## RE: UPA Wahroonga Seniors Housing – Submission Letter – Traffic Engineering

The Owners Strata Plan No. 77814 (10 Ada Avenue) and the Strata Plan 80729 (1-3 Munderah Street) have engaged Metafora to prepare a submission letter addressing traffic related matters for the State Significant Development proposal (SSD-73603959) for UPA Wahroonga Seniors Housing (the Site).

- Preliminary Construction Traffic and Pedestrian Management Plan prepared by Traffix dated 16<sup>th</sup> October 2024 (PCTPMP)
- Construction Management Plan prepared by RJA Projects dated 11<sup>th</sup> September 2024 (CMP)
- Transport and Accessibility Impact Assessment prepared by Traffix dated 14<sup>th</sup> January 2025 (TAIA)

Figure 1: Location of the proposed UPA Seniors Housing (Source: OpenStreetMap and google)

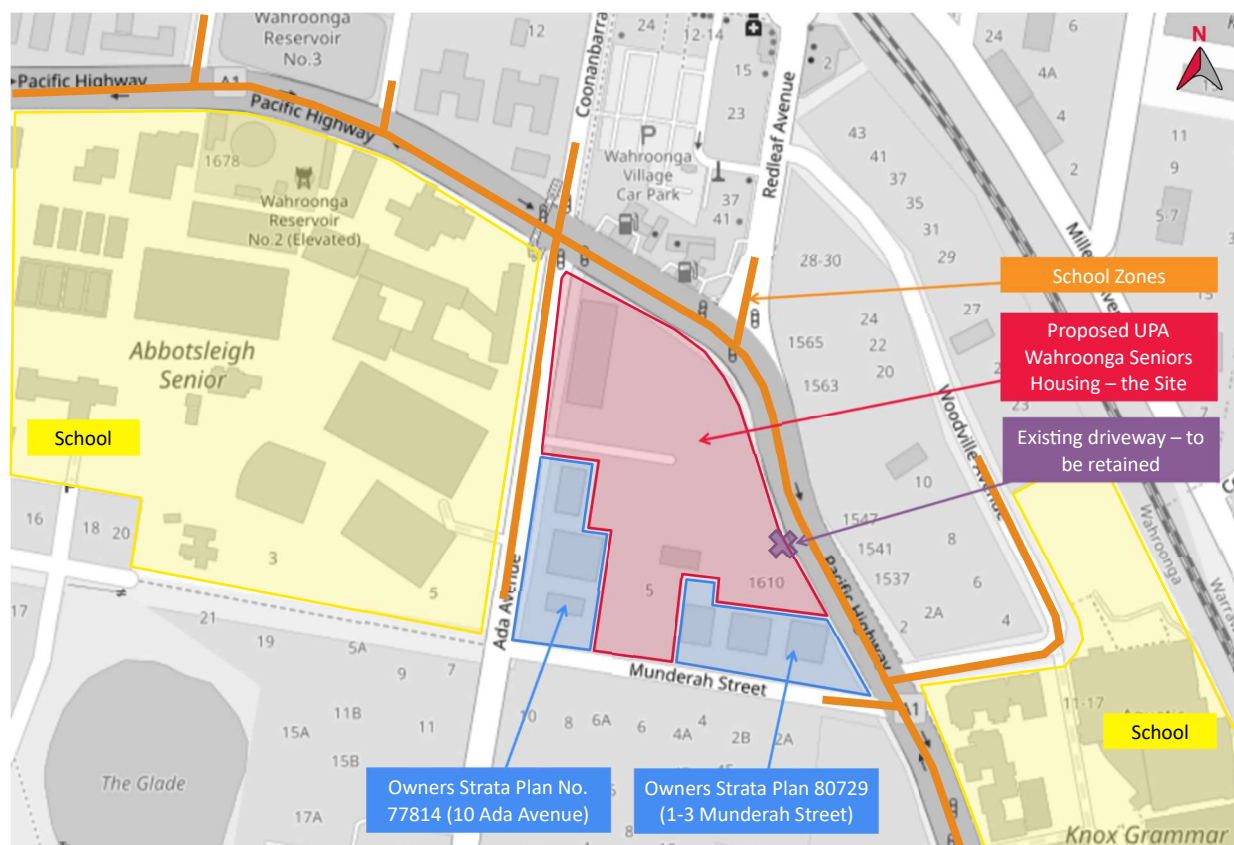
- As shown in Figure 1, the Site is neighbouring two schools (Abbotsleigh Senior to the west and Knox Grammar Senior School to the south-east), with other schools located along the Pacific Highway nearby (such as Warrawee Public School or the Normanhurst Boys High School).

- Considerations for use of the existing driveway along the Pacific Highway
  - There is an existing driveway along the Pacific Highway, which is proposed to be retained as part of the development (refer to Figure 1). It appears feasible to consider its use for construction access as an attempt to reducing impacts on the local community.

Figure 2: Traffic congestion in the morning on Ada Avenue (Source: The Owner Strata Plans)

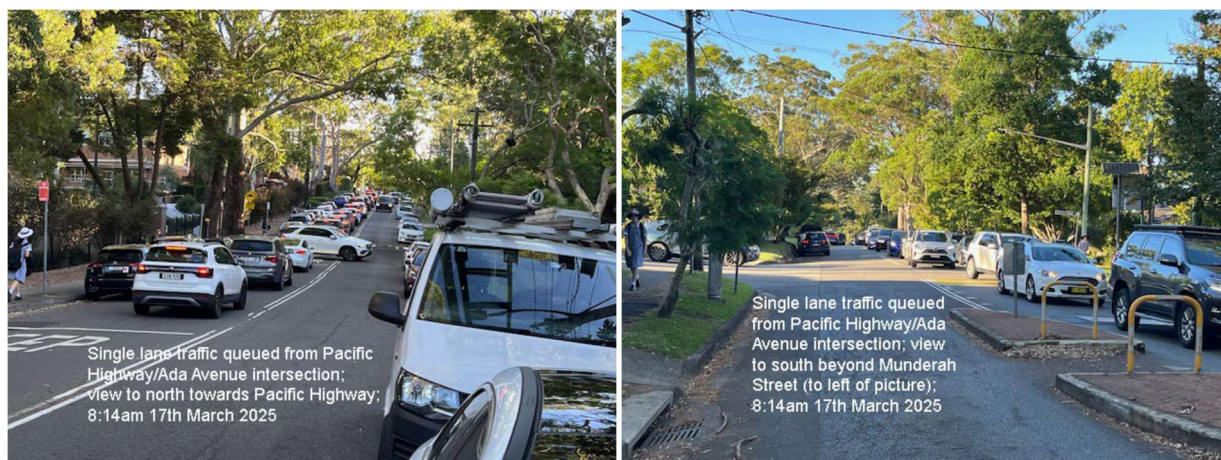
It is requested that a condition of consent be imposed which prohibits construction vehicles to travel within the School Zone times of 8:00-9:30am and 2:30-4:00pm. This is to not add to the vehicular congestion around the surrounding schools, and to reduce potential conflicts between trucks and students walking to and from school. This request is based on the following observations and considerations:

- Residents have reported congestion during school pick-up and drop-off times, particularly along Ada Avenue, as shown in the photos provided (see Figure 2).
